# KITTITAS COUNTY

## DEPARTMENT OF PUBLIC WORKS

**TO:** All Staff  
**FROM:** Public Works Plan Review Team  
**DATE:** April 24, 2024  
**SUBJECT:** LP-24-00002 Nelson View

NELSON VIEW PLAT PREPARED FOR NELSON VIEW LLC A PORTION OF THE SOUTHEAST QUARTER OF SECTION 20 TOWNSHIP 20 NORTH, RANGE 14 EAST, W.M. KITITITAS COUNTY WASHINGTON		
DWN BY	DATE	JOB NO.
DLP/GW/DBM	03/2024	230165
CHKD BY	SCALE	SHEET
DLP/DBM	1"=200'	2 OF 2

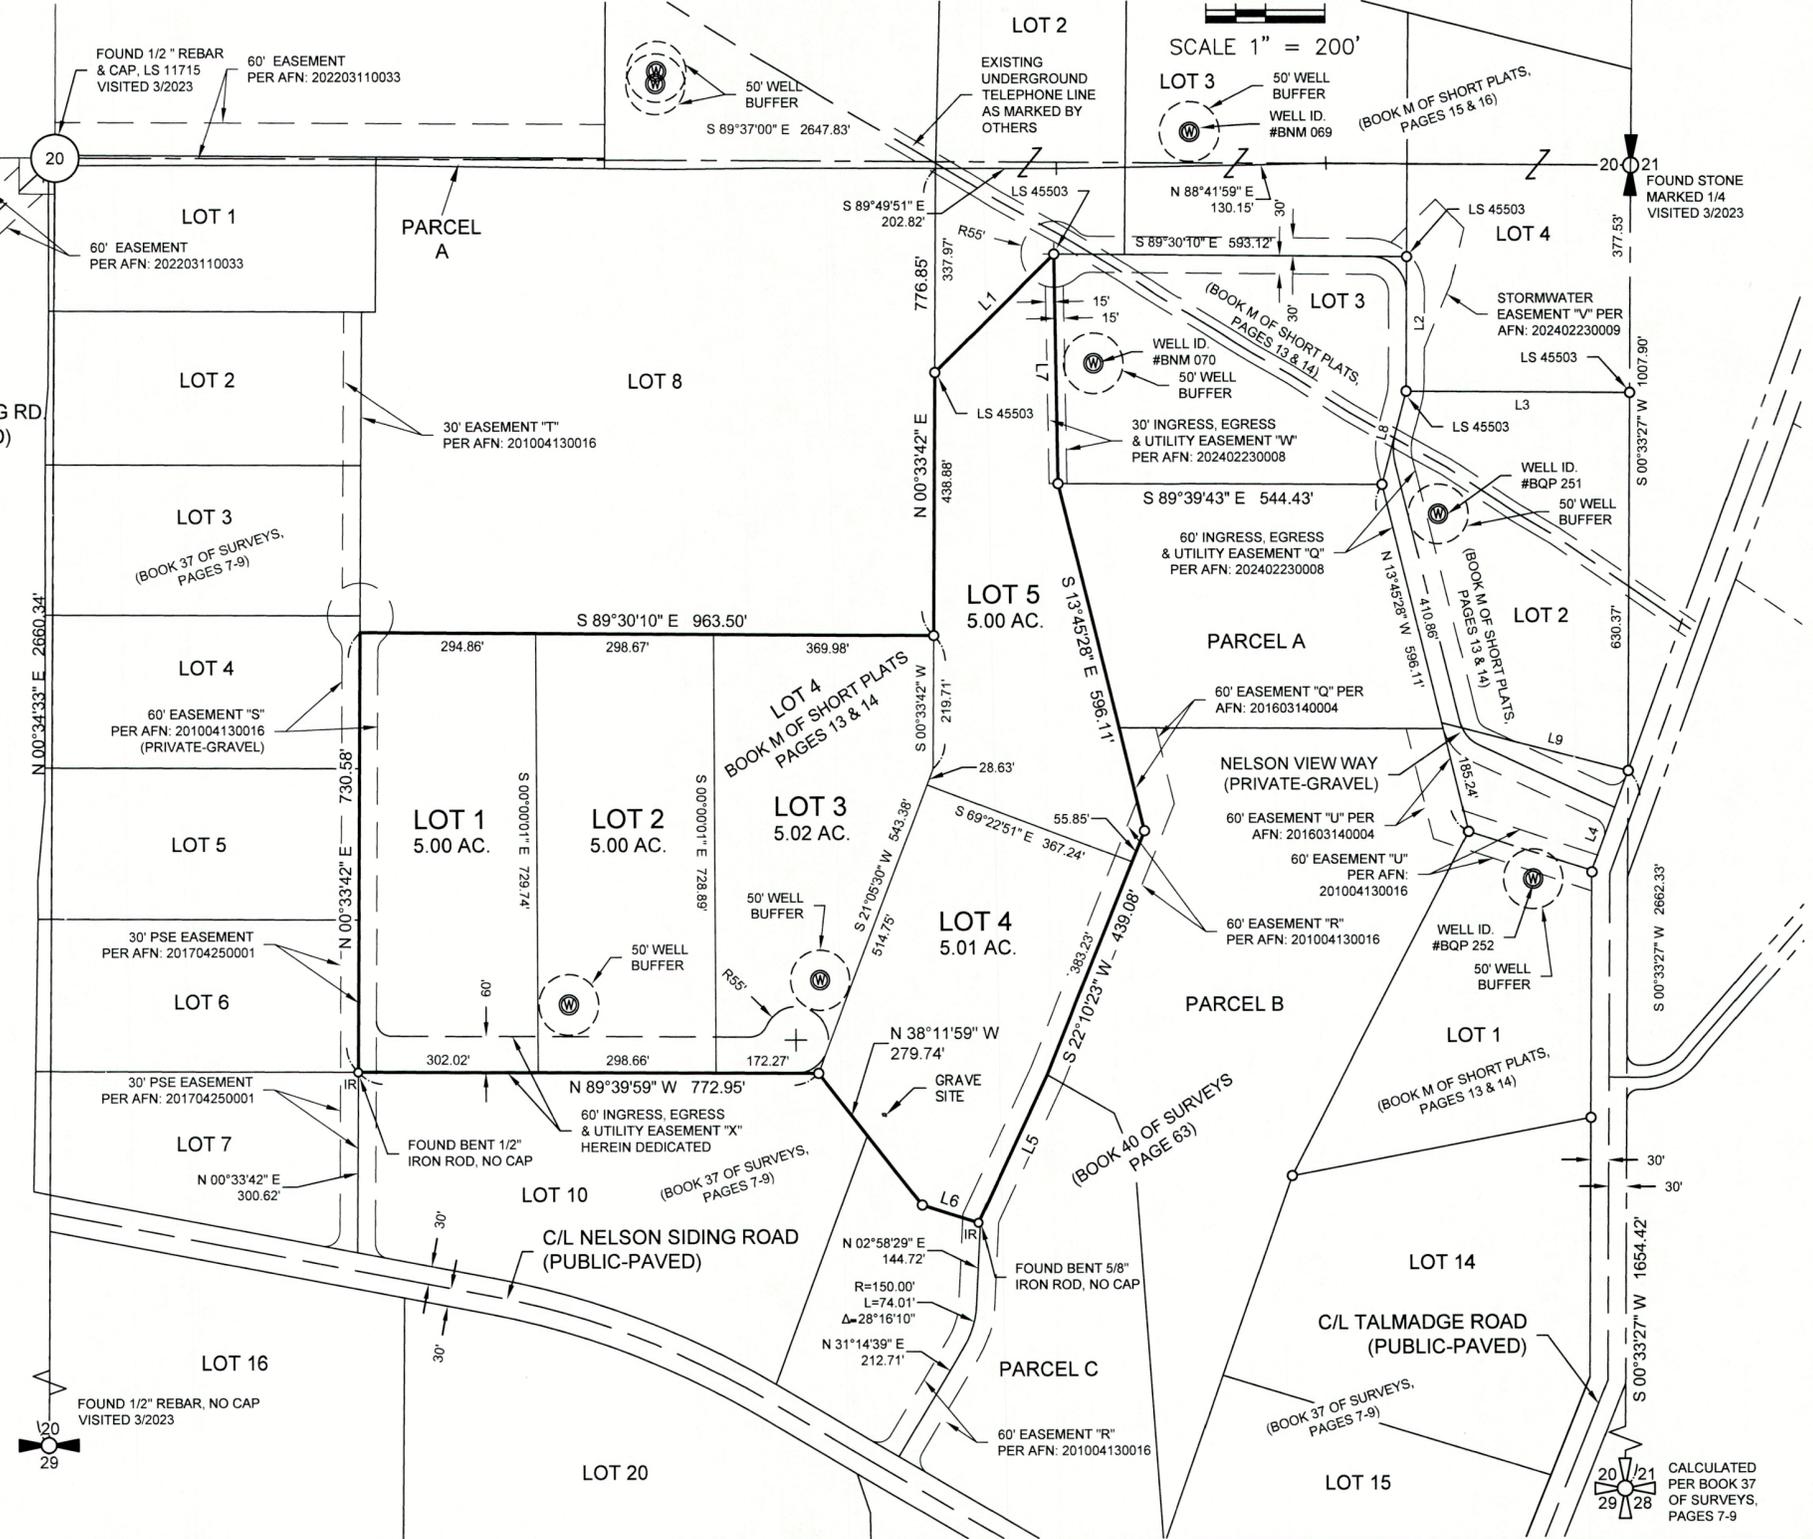
<b>SURVEY</b>	<p>The following elements are missing from the Prelim Plat application:</p> <ol style="list-style-type: none"> <li>1. Engineer (or firm) of Record</li> <li>2. Sewage Note</li> <li>3. Potable Water Note</li> <li>4. Existing locations of fences and structures</li> <li>5. Road surfacing and width</li> <li>6. Contours, together with a statement addressing the requirements of WAC 332-130-145.</li> </ol> <p>Applicant is directed to review Kittitas County Code 16.12 for prelim. drawing requirements. (JT)</p>
<b>TRANSPORTATION CONCURRENCY</b>	<p>Requirements were met with Transportation Concurrency Management Application TC-23-00005 (KAH)</p>
<b>FLOOD</b>	<p>Parcel #963647 is not located in the FEMA identified special flood hazard area (100-year floodplain). (SC)</p>
<b>WATER MITIGATION/ METERING</b>	<p>The following comments outline the requirements for legal availability of water and metering for the proposed plat:</p> <p>The applicant must provide legal water availability for all new uses on the proposed lots of this project, which can be provided through mitigation certificates. Prior to final plat approval and recording, the following conditions shall be met:</p> <p>In accordance with KCC Chapter 13.35.027, the applicant shall provide one of the following documents before final plat approval:</p> <ol style="list-style-type: none"> <li>1. A letter from a water purveyor stating that the purveyor has adequate water rights and will provide the necessary water for the new use;</li> <li>2. An adequate water right for the proposed new use; or</li> <li>3. A certificate of water budget neutrality from the Department of Ecology or other adequate interest in water rights from a water bank.</li> </ol> <p>All applicants for land divisions shall also submit information on "proximate parcels" held in "common ownership" as those terms are defined in WAC 173-539A-030 and otherwise demonstrate how the proposed new use will not violate RCW 90.44.050 as currently existing or hereafter amended.</p> <p>Failure to obtain mitigation before commencement of an activity requiring mitigation shall be a code violation subject to enforcement under Title 18 KCC.</p>
